# Memo.

**Subject:** S6/2010/1710/FP – Land at Georges Field, Hatfield Park

**Formation of visitor parking area, paths, landscaping and ancillary works at land adjacent to Georges Field. Removal of car park north of Hatfield House and provision of soft landscaping**

I have reviewed the above application and refer to the Landscape Statement dated 21<sup>st</sup> July 2010, site plan 843/GC/002C and proposed 843-003.

*043-002*

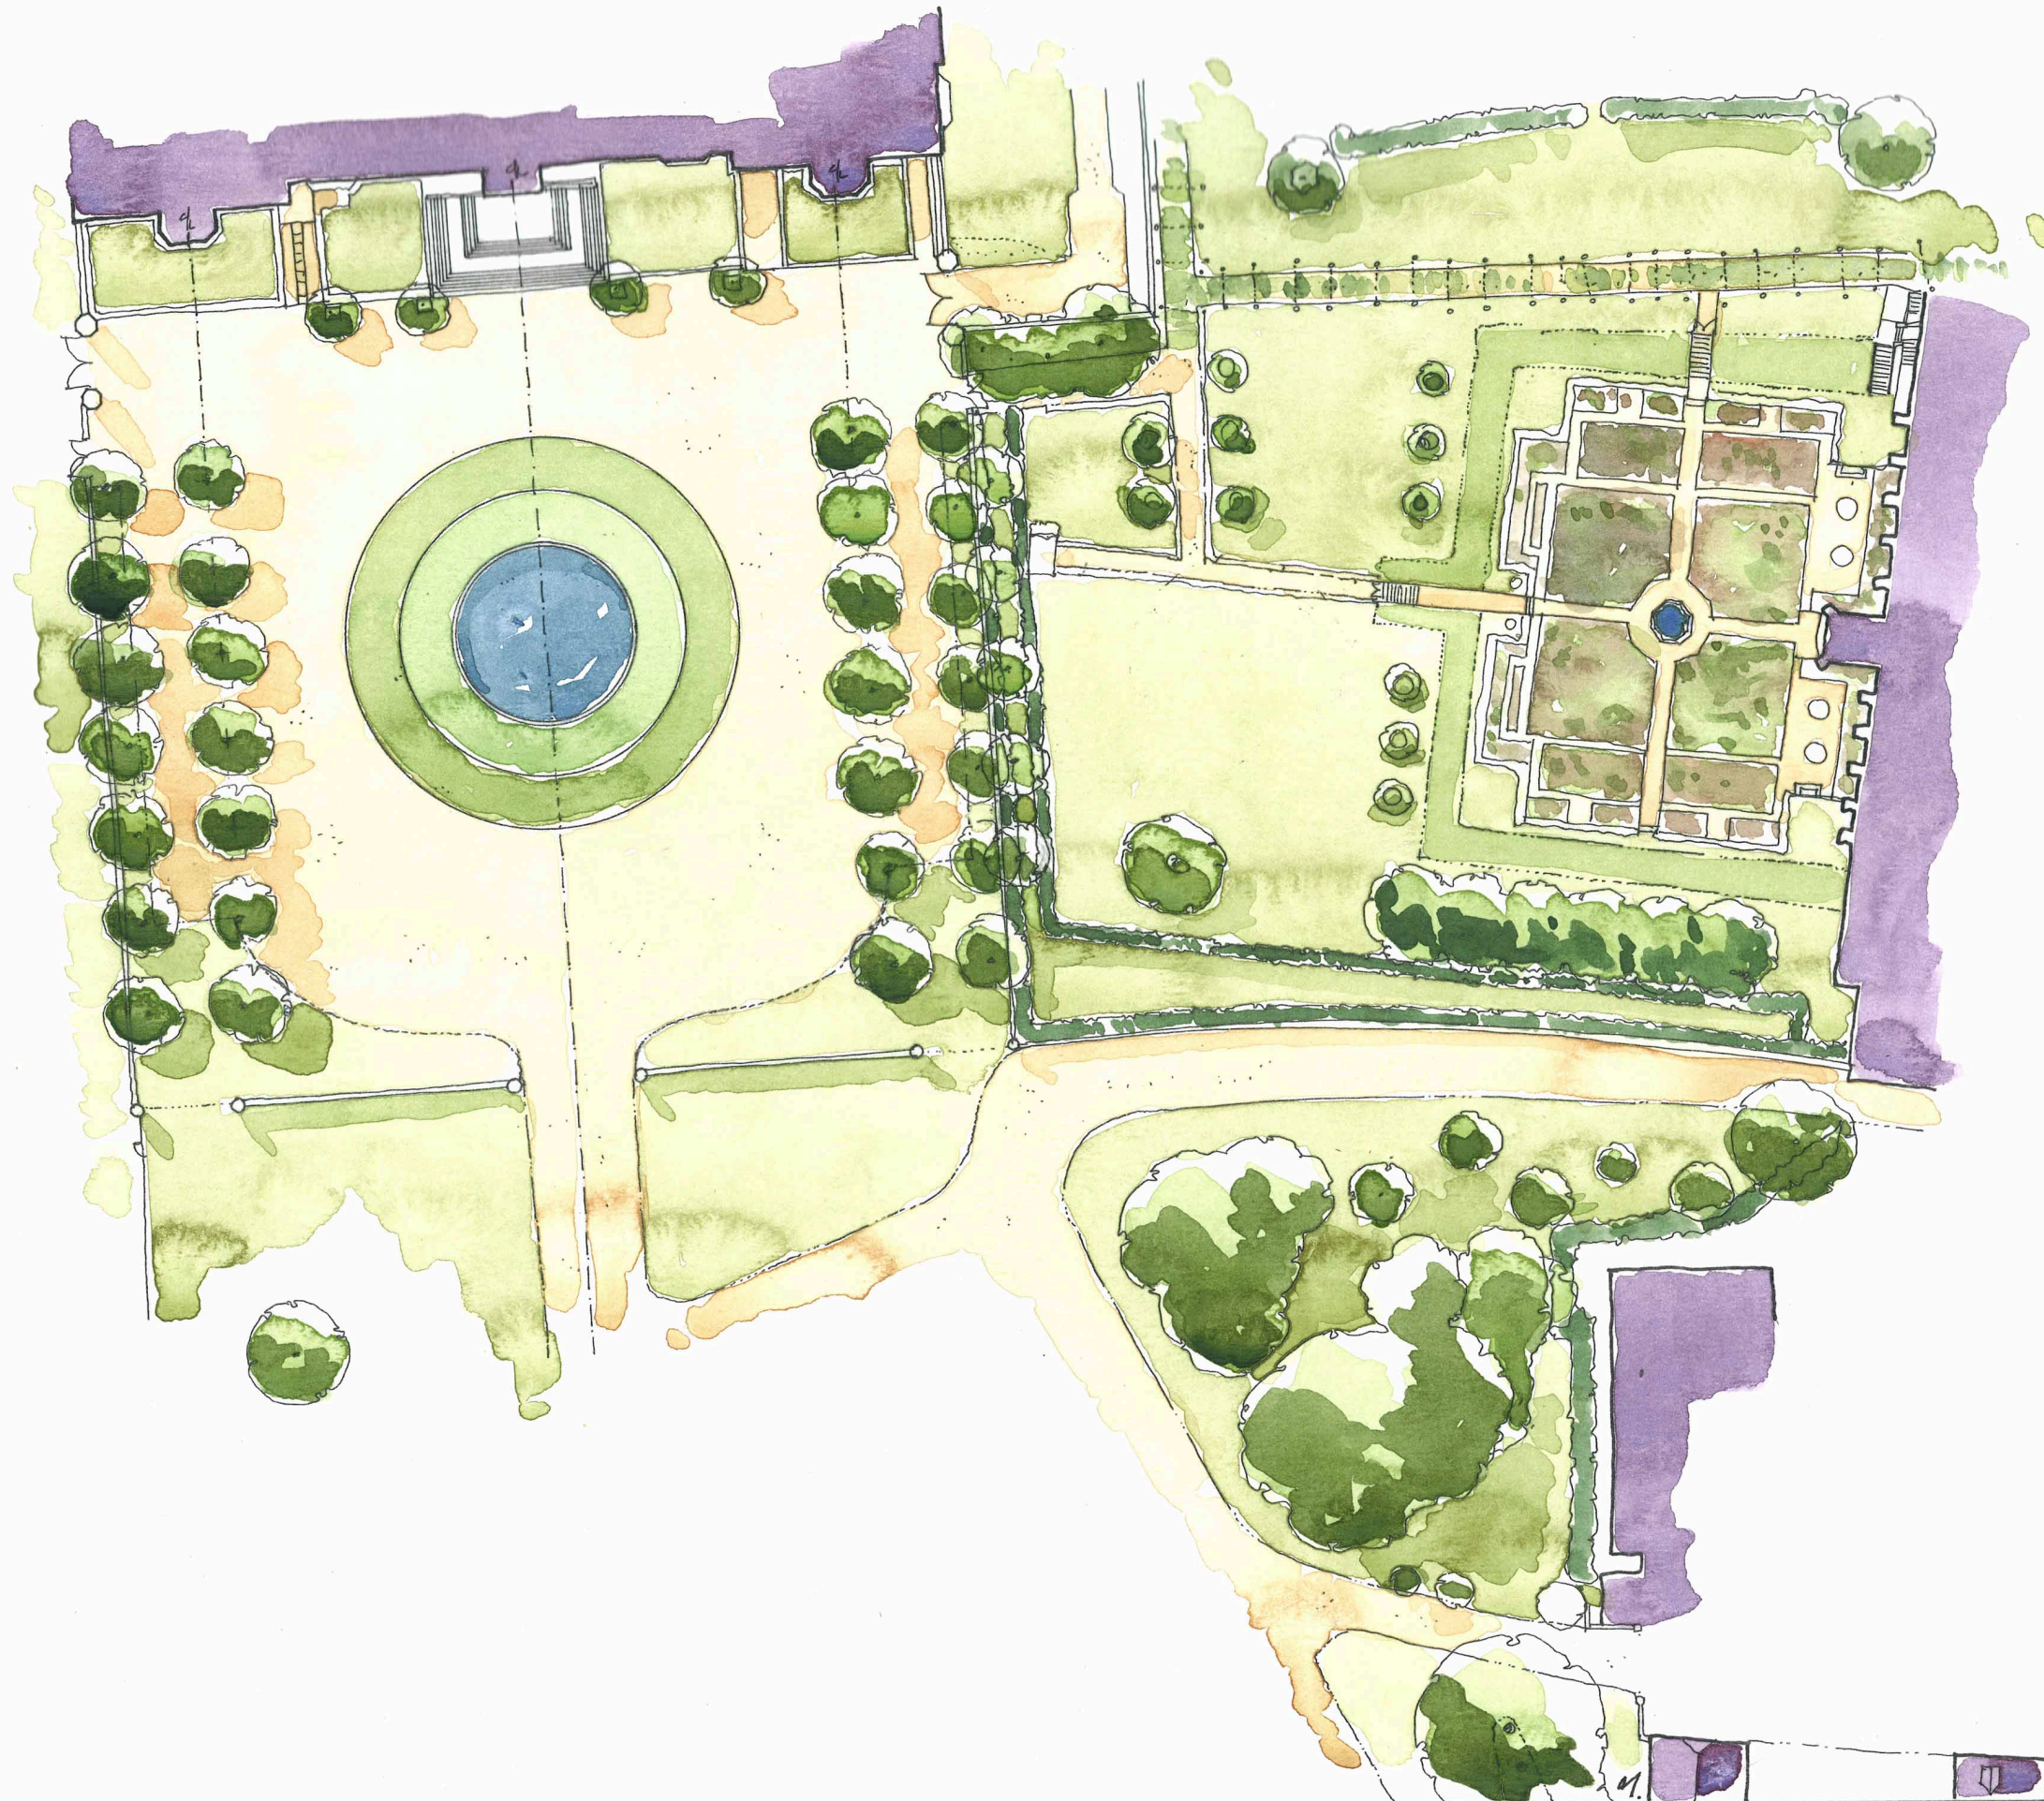
The area to the front of the house which is currently a car park is to be re-landscaped with a water feature and tree planting. It would be appropriate to request some further details about the proposed landscaping. As the new scheme is not particularly overlooked it can concentrate wholly on style and design to complement the house and wow the visitors.

In summary, overall I do not have objections to the proposal however more information is required. Before works start on site an Arboricultural Impact Assessment must be submitted for approval. Landscaping details need to be submitted for approval for both current and proposed car parks. These should be detailed plans with a planting schedule including planting densities, size of planting material, species etc.

DRAWING NUMBER:
 843/AC/02C

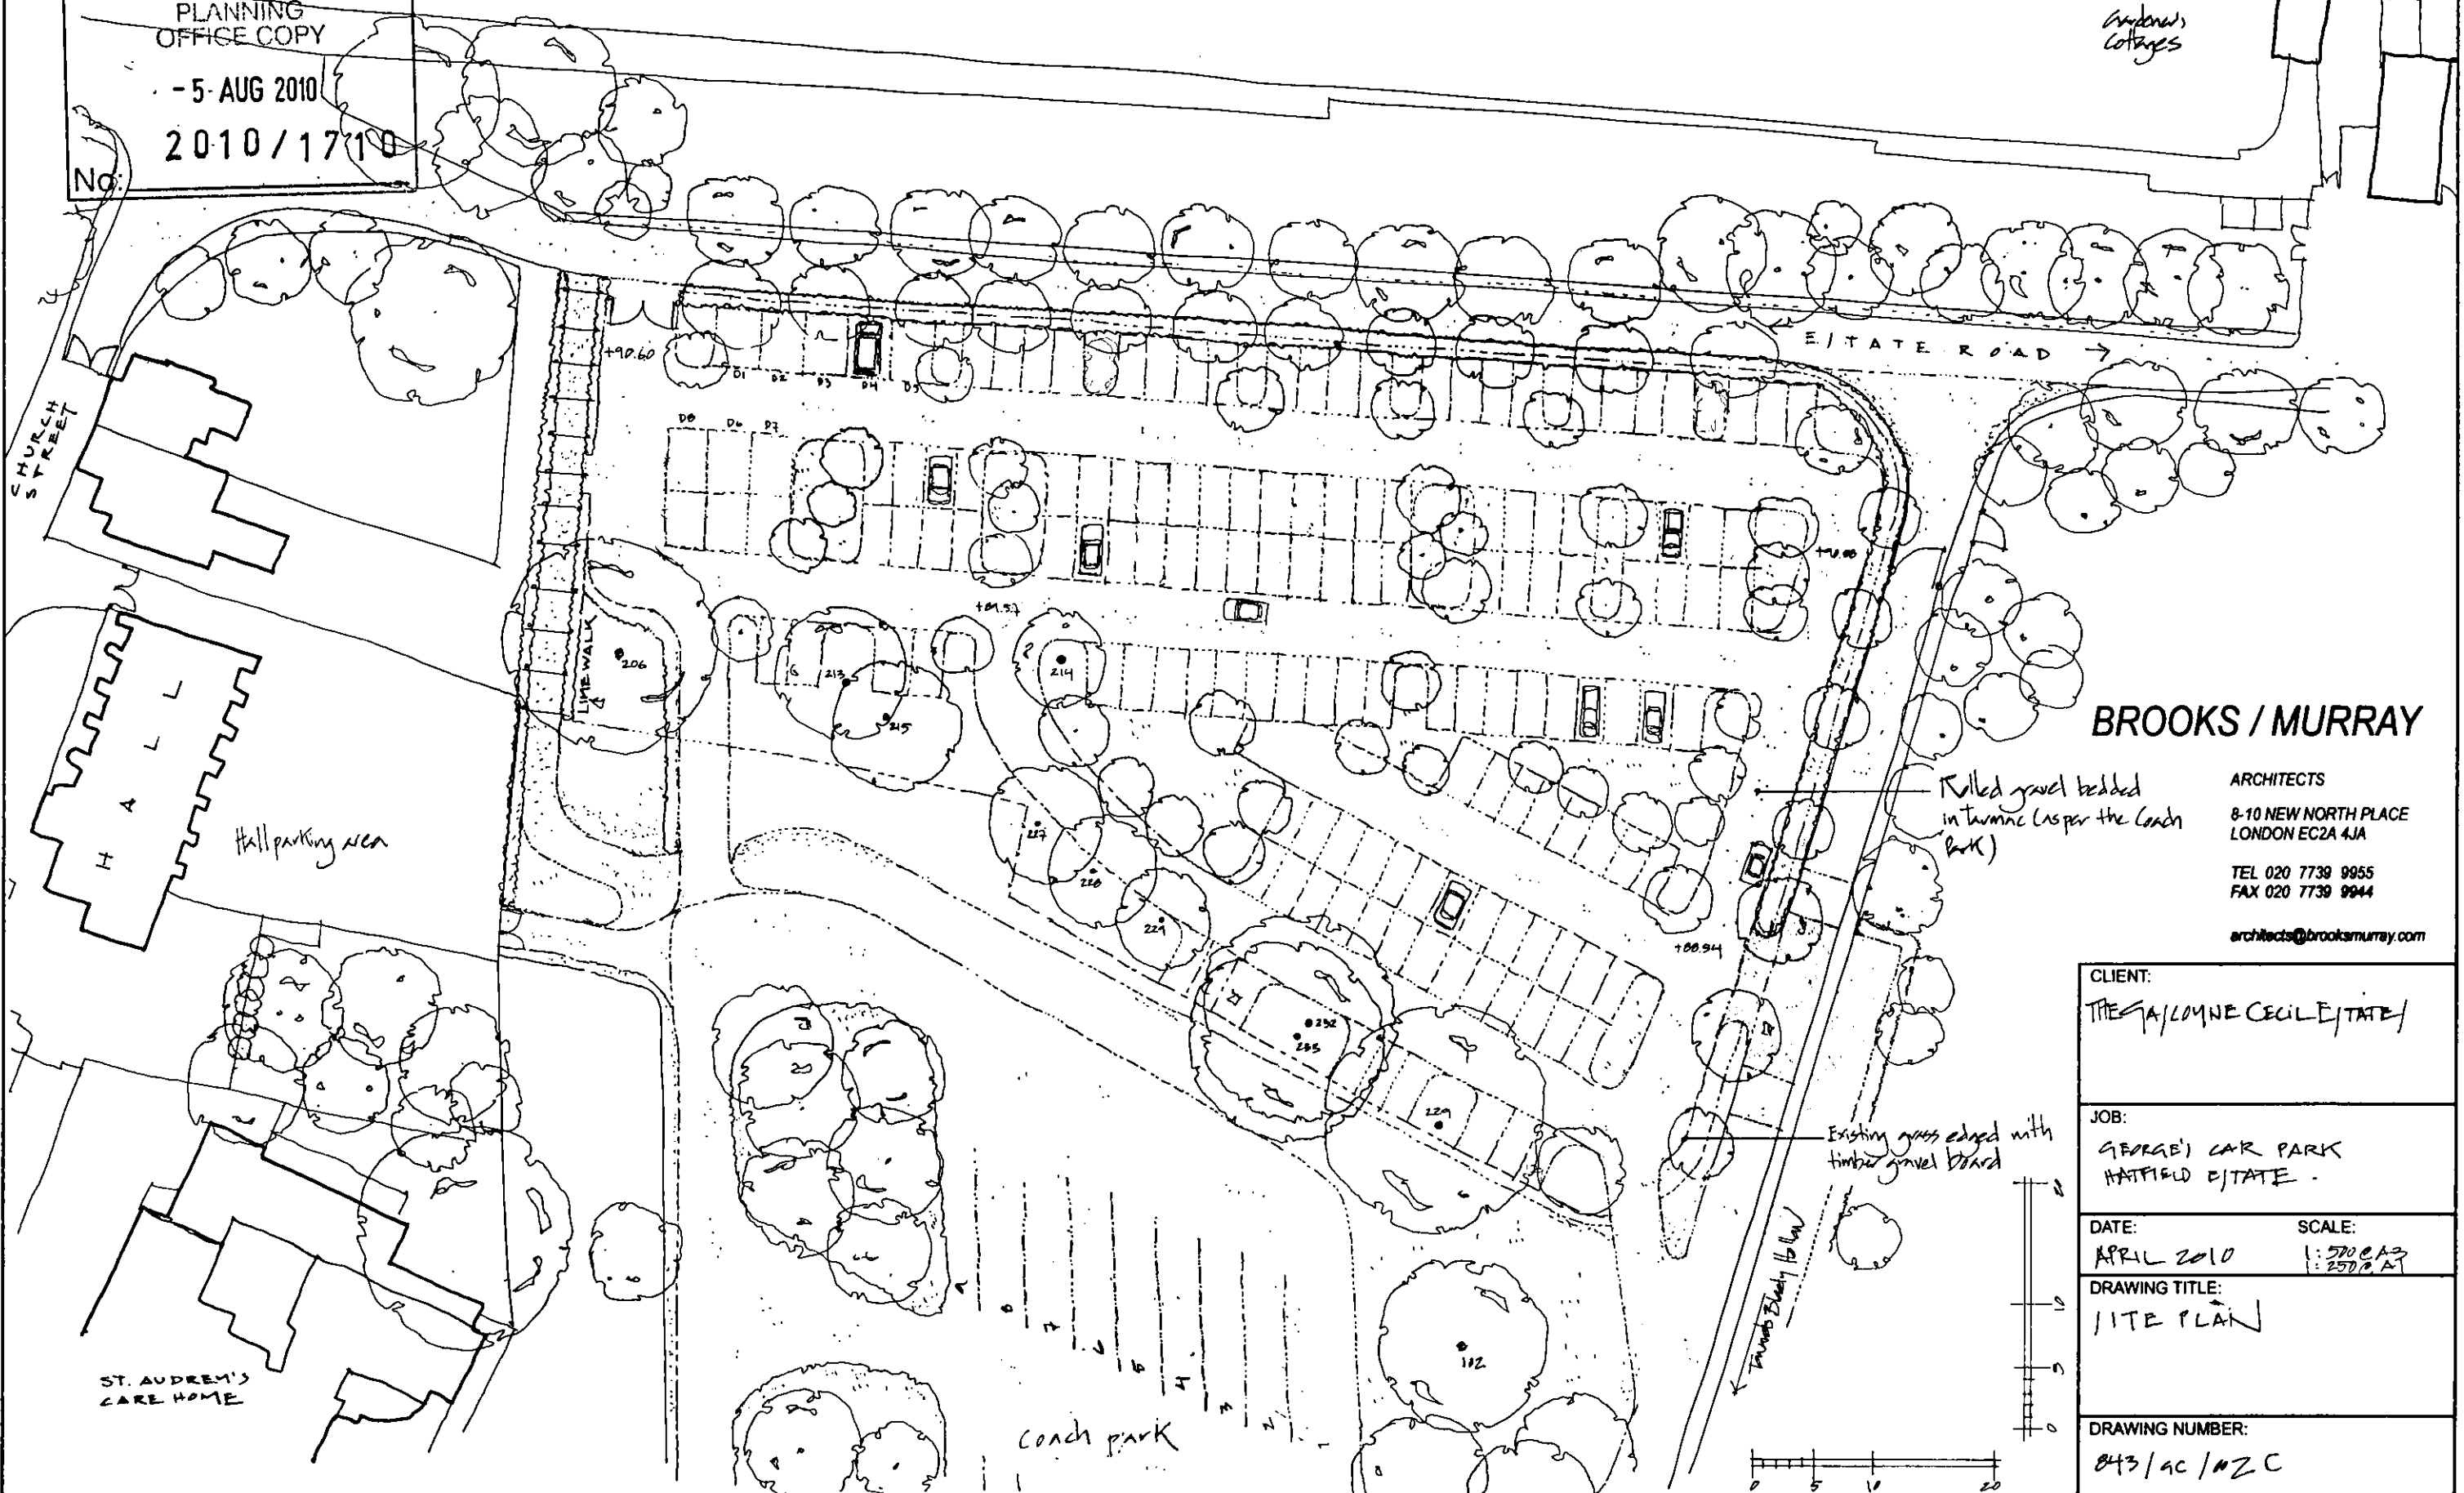
No Arboricultural Impact Assessment including a full tree schedule with proposed pruning works, felling and root protection details were included with the application. The mature trees on site and in particular the belt of trees which separate the coach and proposed car park will be especially valuable to screen both the estate from the railway, car garage and A1000 and vice versa. This issue has been broadly referred to in the Landscape Statement but not in sufficient detail. This issue needs to be resolved before works start on site. The document should comply with BS5837:2005 Trees in Relation to Construction and will be very similar to the document previously used for the coach park.

The area which will be the new car park needs to have a carefully considered landscape

plan. As this area is overlooked by numerous houses and a care home. Overall I think the layout gives a nice balance of trees to hard standing and the scattered effect aids solar shading. I would have expected to see a little more landscaping between the car park and the rear of 1-13 (odds) Church Street, including hall and St Audrey's Care Home. These are the people who are going to be effected most by noise, fumes etc. The Landscape Statement outlines some of the suggested planting species. These are quite reasonable, though rowan does not thrive in this Borough and are best avoided in managed areas. I would also query why white poplar is to be used as a screening tree in this particular location.
